**WELWYN HATFIELD COUNCIL – DEVELOPMENT CONTROL**  
**DELEGATED REPORT**

<b>APPLICATION No:</b>	<b>S6/2008/2412/FP</b>
------------------------	------------------------

This application seeks full planning permission for erection of part two storey rear extension, first floor bay window and replacement garage to the side and front of the existing house.

First Floor Plan

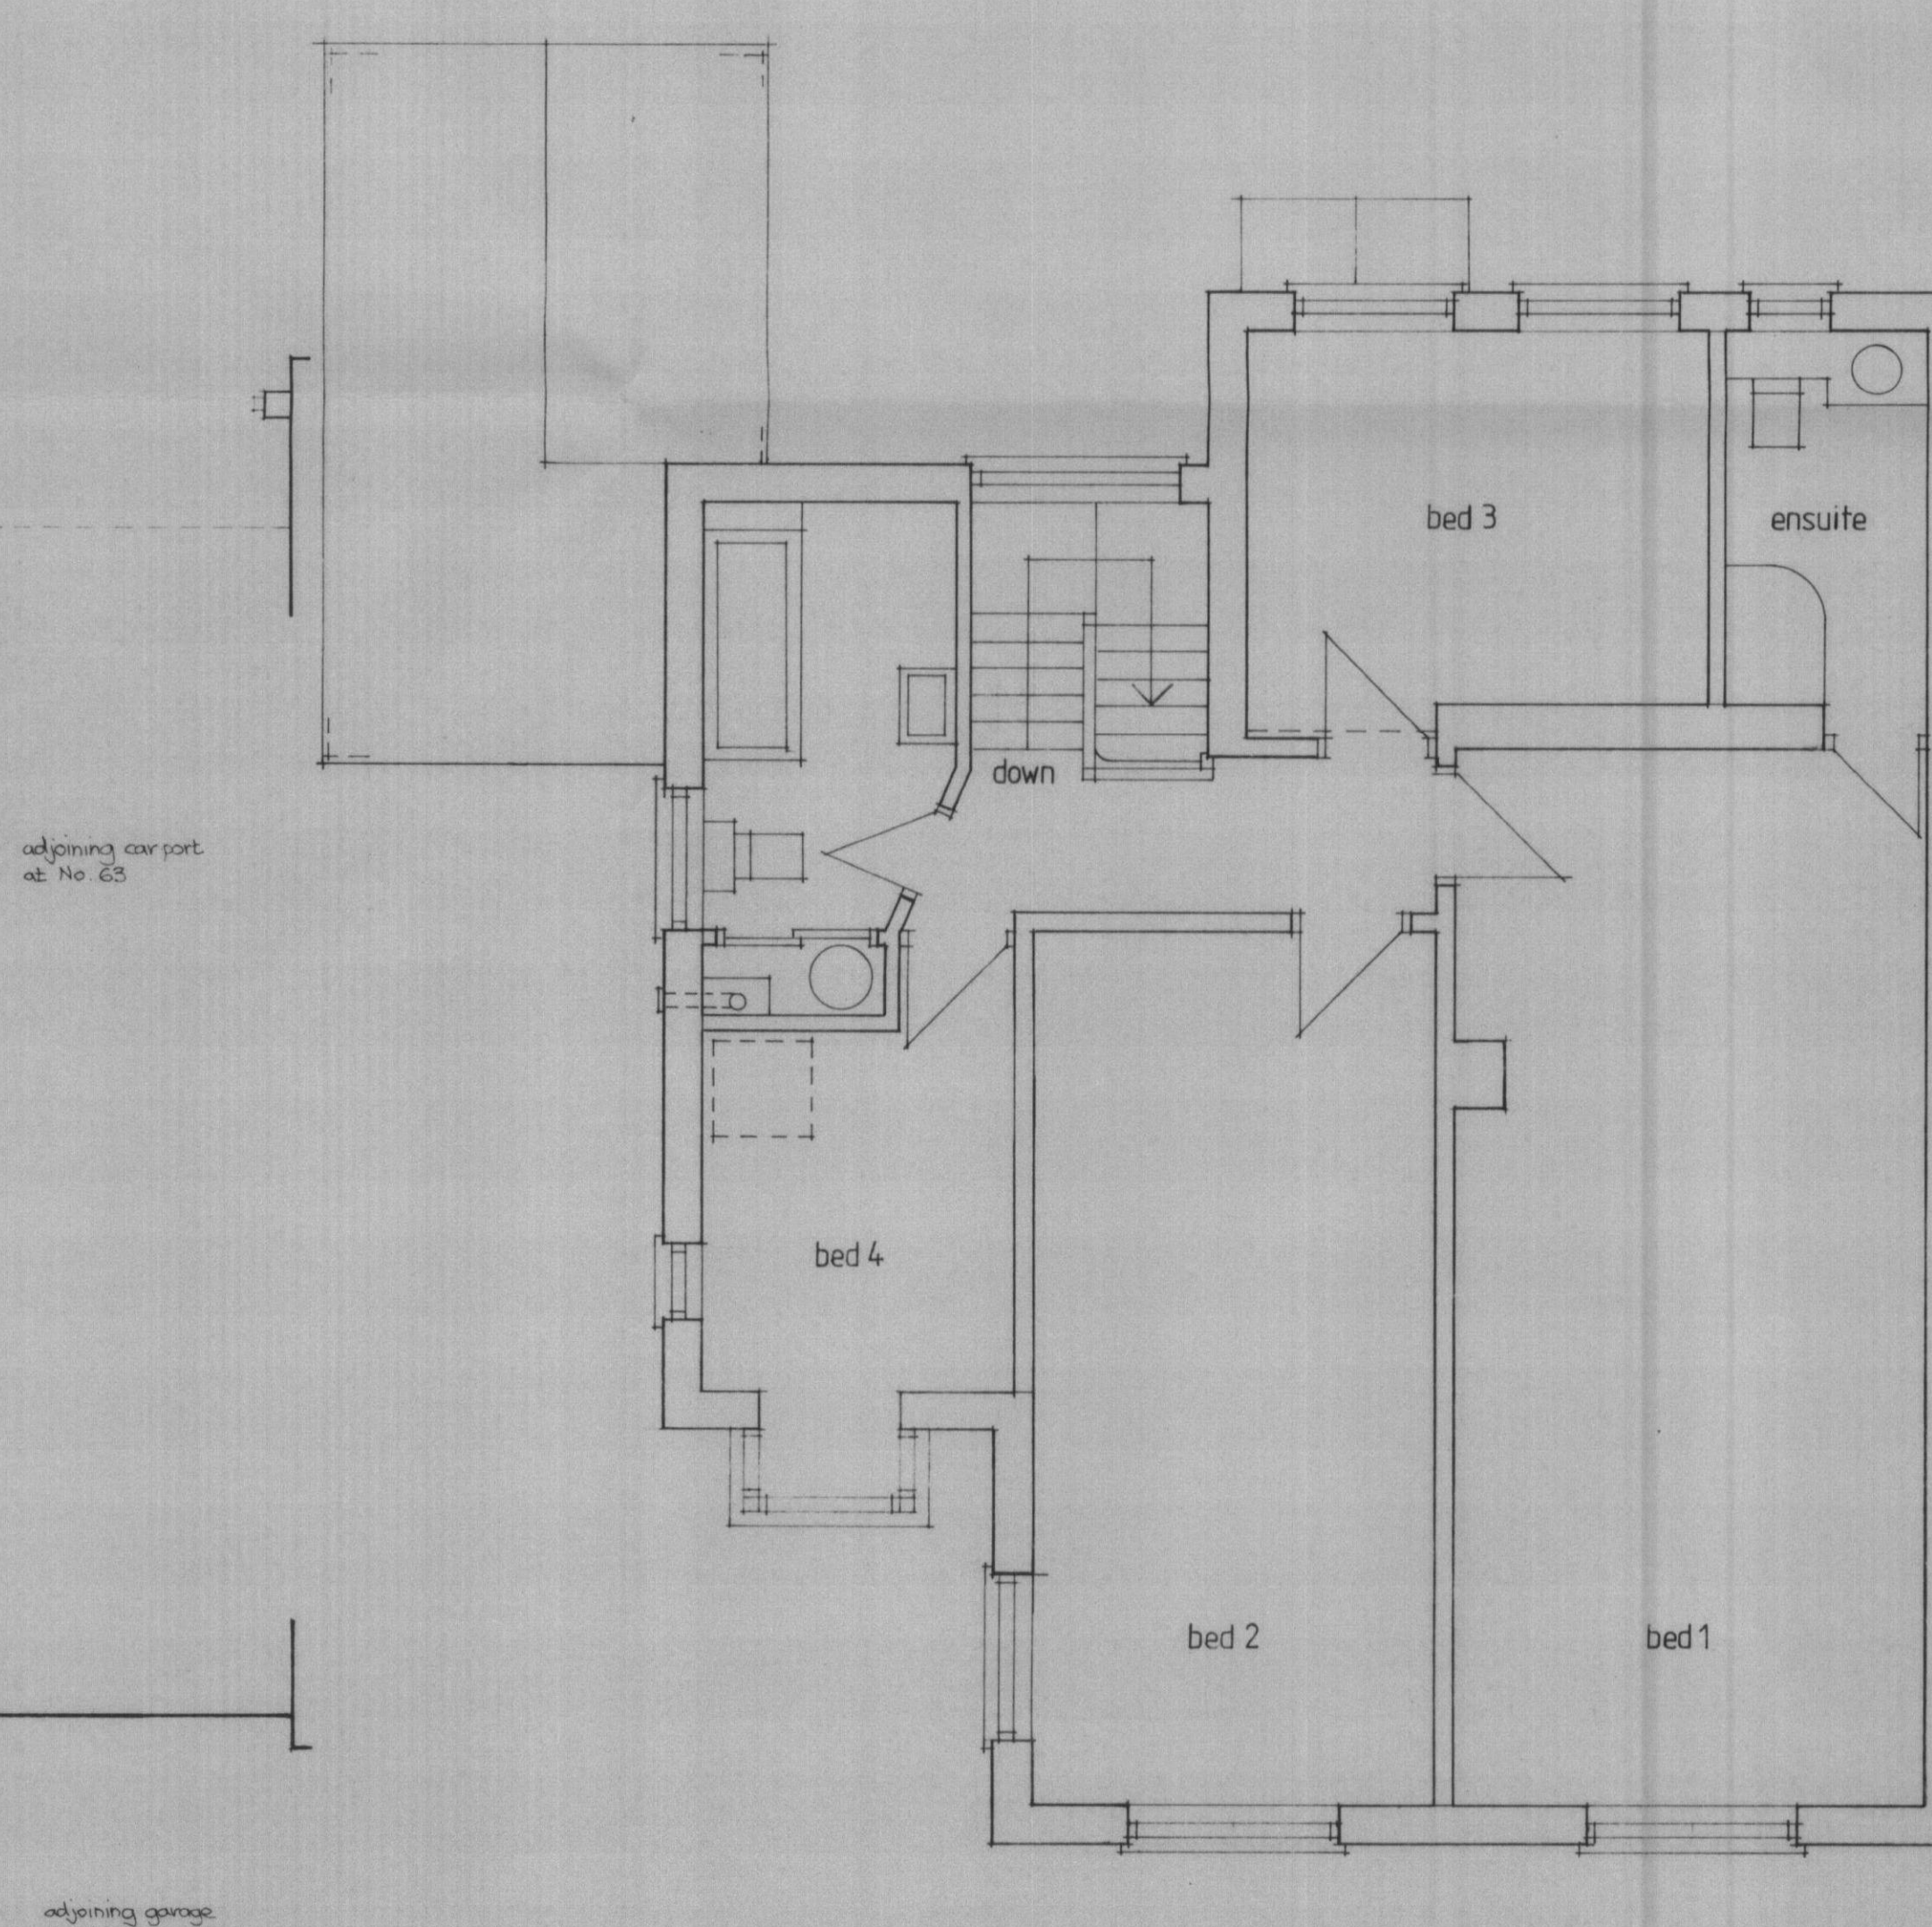
REASON: The amended plans for the garage submitted on the 13<sup>th</sup> Jan have not been updated with a proposed roof plan. Details are required to ensure that the design is in accordance with policies D1 and D2 of the Welwyn Hatfield District Plan 2005.

1. C.2.1 – Time Limit
2. C.13.1 – The development/works shall not be started and completed other than in accordance with the approved plans and details 0801/03C received and dated 13 February 2009
3. C.5.2 – Matching Materials
4. C.7.9 – Fixed and Obscure Glazing (The north flank elevation of the proposed extension and the north facing window within the first floor bay)
5. Prior to the commencement of the development hereby approved, details of the proposed roof plan shall be submitted to the Local Planning Authority for approval in writing. Subsequently the development shall be built in accordance with the approved details
